Reference number: TR010032
Document reference: TR010032/EXAM/10.44

A122 Lower Thames Crossing
National Highways
Woodlands
Manton Lane
Bedford
MK41 7LW

A122 Lower Thames Crossing (Reference Number TR010032)

Third Change Application

Drawing file: TR010032 / TR010032-005281-Additional Submission - Land Plan - v6 Deadline 5 - Sheet 45 - Visual Aide.pdf

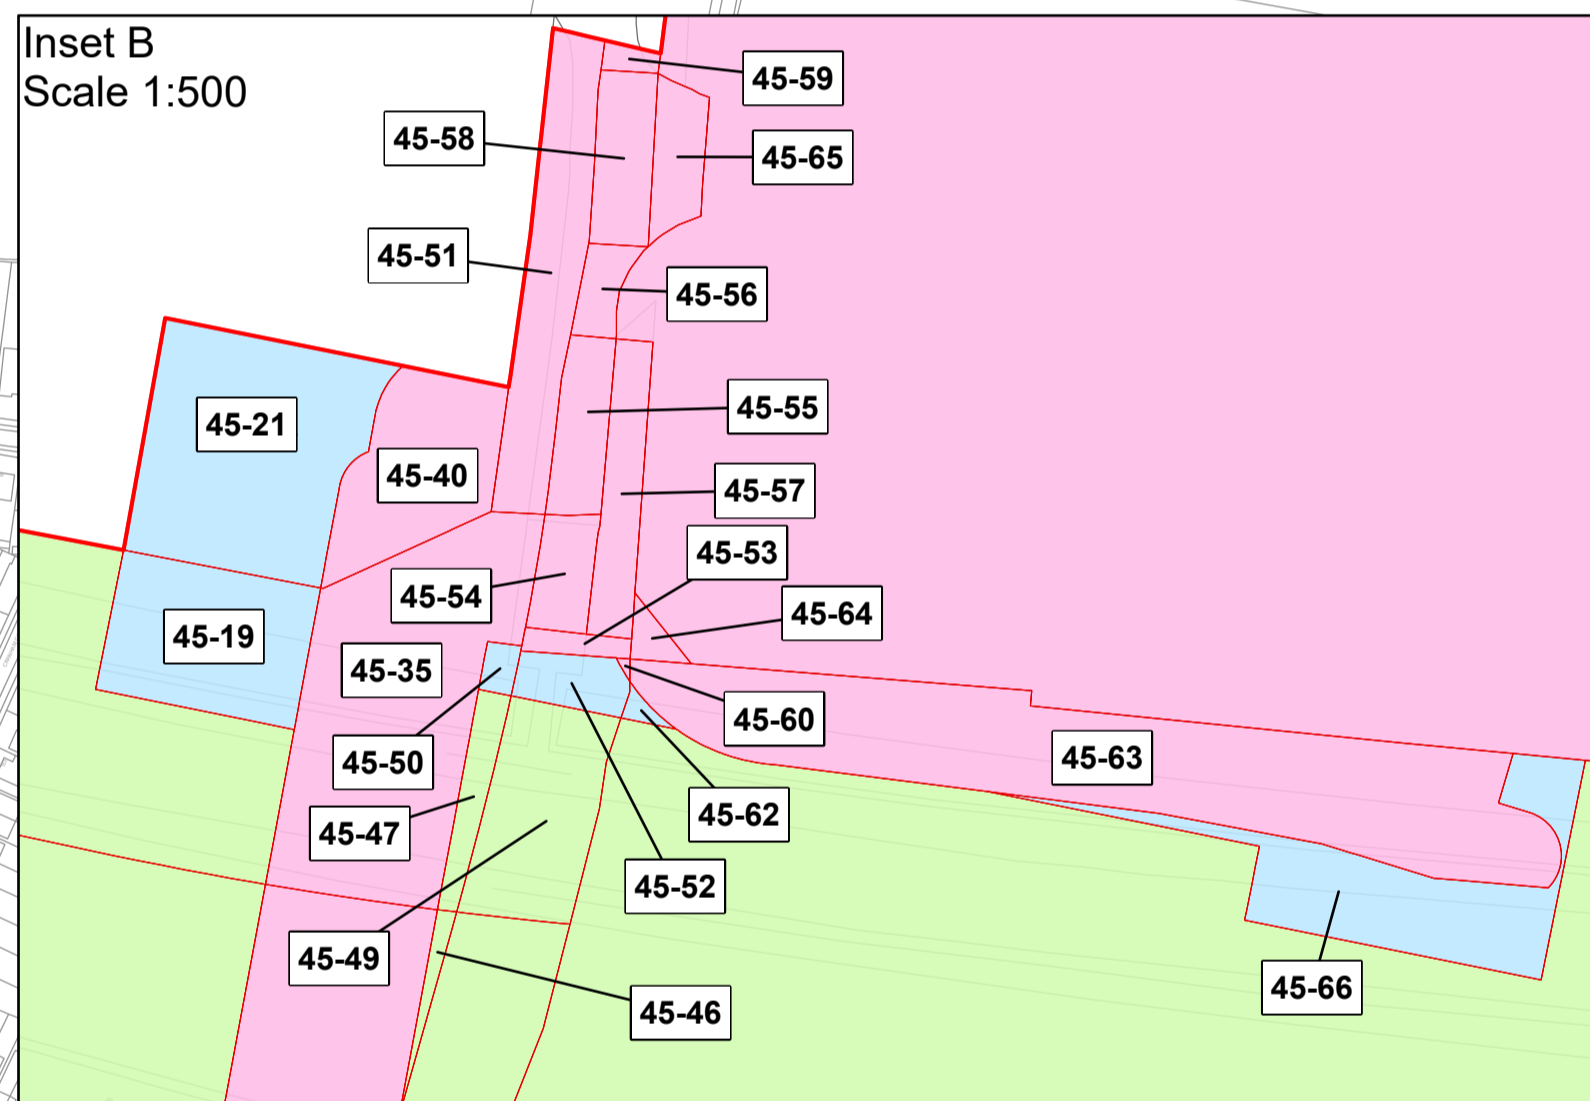
- 3.2.1 Proposed change EC03 seeks additional flexibility to increase the Highway Works horizontal Limits of Deviation by approximately 580 sqm to the north of the A127E WCH overbridge to avoid any conflict with the delivery of a new vehicle bridge proposed by St Modwen, as part of the Brentwood Enterprise Park (BEP).

- 3.2.2 The Applicant's A127E WCH bridge is as described under Work No. 9Z of Schedule 1 of the draft Development Consent Order [[REP5-024](#)] and shown on sheet 45 of 2.6 Works Plans (Volume C) Composite (Sheets 21 to 49) [[REP5-020](#)].

- 3.2.4 The Applicant has, and will continue to, engage with St Modwen, the landowner and other parties throughout the detailed design of both projects, to seek to ensure a coordinated approach to implementation is taken. To allow a reasonable amount of flexibility in the detailed design for the Applicant to accommodate the BEP bridge the Applicant seeks to increase the Limits of Deviation to the north of the A127E structure.

- 3.2.5 The land required for the proposed increase to the Limits of Deviation is already identified for permanent acquisition in the Land Plans Volume C (Sheets 21 to 49) [[REP5-008](#)] so there is no change to land requirements. The change would not involve any modification to the vertical limits of deviation and would not result in any new or materially different environmental effects.
